From: Sue Howell
Sent: 05 March 2018 12:18
To: Planning.Responses
Cc: David Easton
Subject: RE: Planning Consultation on: Y/91/17/OUT

Comment from Greenspace

APPLICATION Y/91/17/OUT

Description of Works: Outline application for the development of up to 250 residential dwellings (Class C3), vehicular access, public open space, ancillary works and associated infrastructure. Departure from the Development Plan

FIGURE 17. Vision for the allocation site

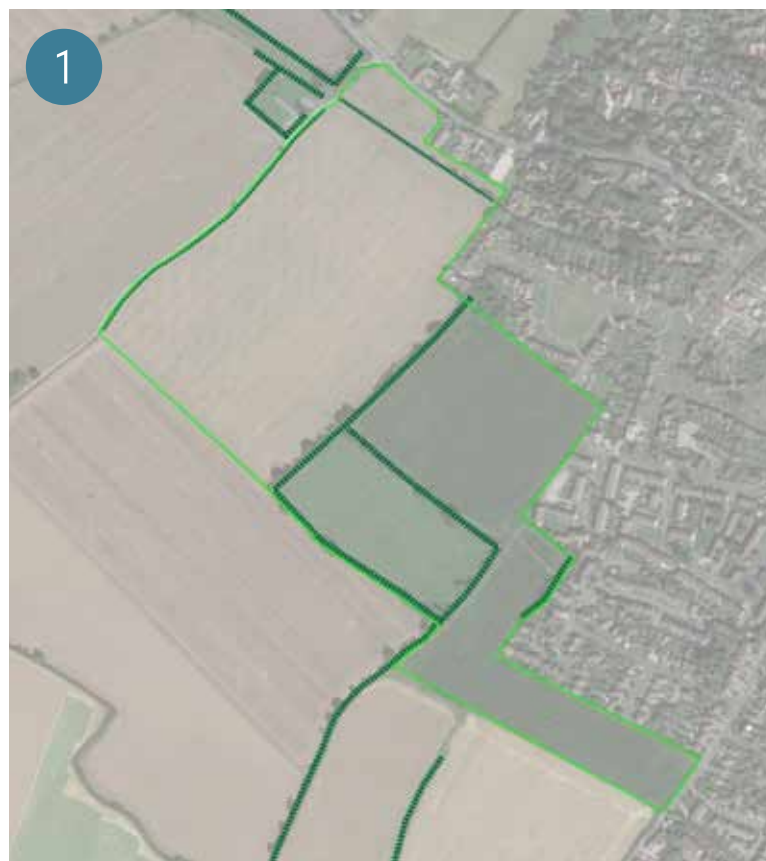
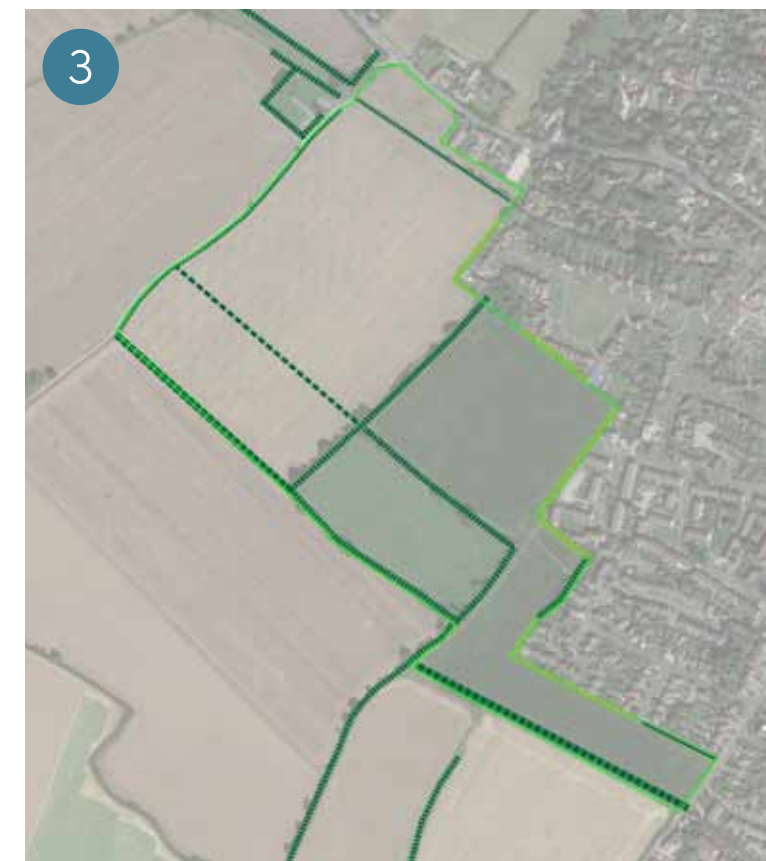
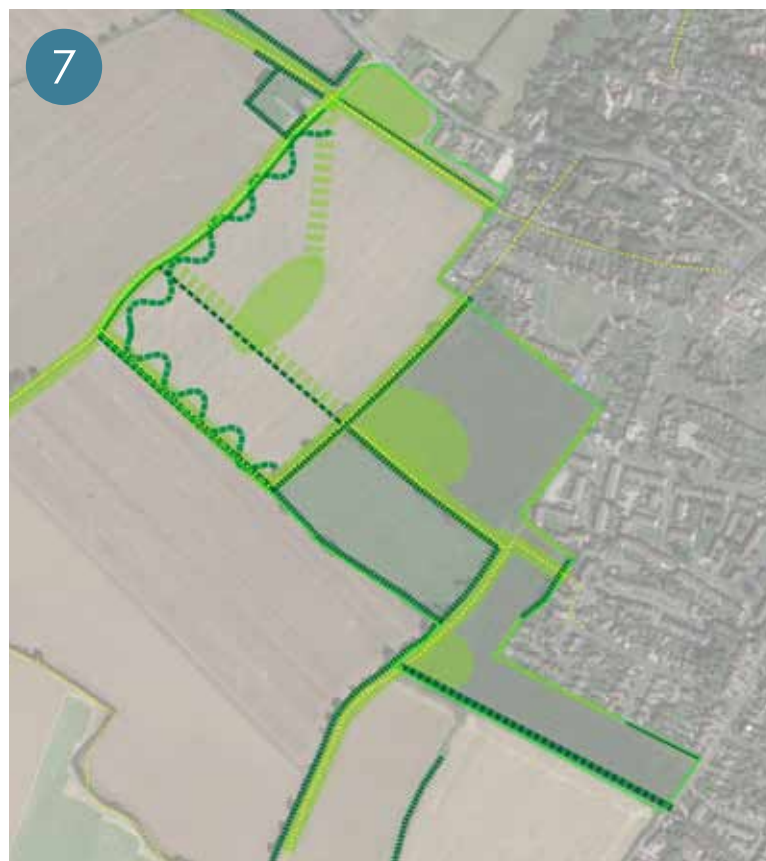
This development proposal is for up to 250 dwellings. **We note that a high proportion of the indicated Open Space areas are detailed as SuDS features. These raise concern as not therefore providing useable Public Open Space in these areas therefore diminishing the POS offer which would appear to being provided within the site.** It would appear that in excess of 50% of the POS indicated is dedicated to SuDS provision. Confirmation and cross section of these SuDS areas should be provided along with the anticipated timescale that these would be water holding bodies. The full implication of the SUDS within the POS needs to be provided including its future management and maintenance. The recommendation that these are subject to RoSPA or similar organisation inspection should be noted. Indication must be provided as to whether these are likely to be wet or dry areas; this has implications where situated near to residents and play areas. Where they are to remain wet for long periods their safety in must be assessed regarding the close proximity to these large residential areas. Any such SUDS features including swales, wet balancing ponds, reed beds and wetland areas should be designed as beneficial wildlife, amenity and landscape features as incorporated as part of an open space or landscaping scheme for the development.

Provision of LAP, LEAP, MUGA (Multi-Use Games Area) and NEAP-contribution would be sought on site, with confirmation of play provision being provided to be submitted and approved. The LEAP location is indicated, but no provision of LAPs which would also be required presently shown within

the masterplan. The indicative layout for the LEAP is integrated centrally within the development where it could provide connectivity with existing residential surrounds.

The masterplan layout shows accessibility to the larger areas of open space particularly to the periphery – however as stated above the usability of these would now be in question because of the extensive SuDS now shown in these areas. Some corridor linkage has been considered, however the primary area of useable POS shown to the north of the development does not provide connecting greenspace and park/ amenity/ children's play space. POS and green corridor should be integrated within and around the development and safely accessible to residents.
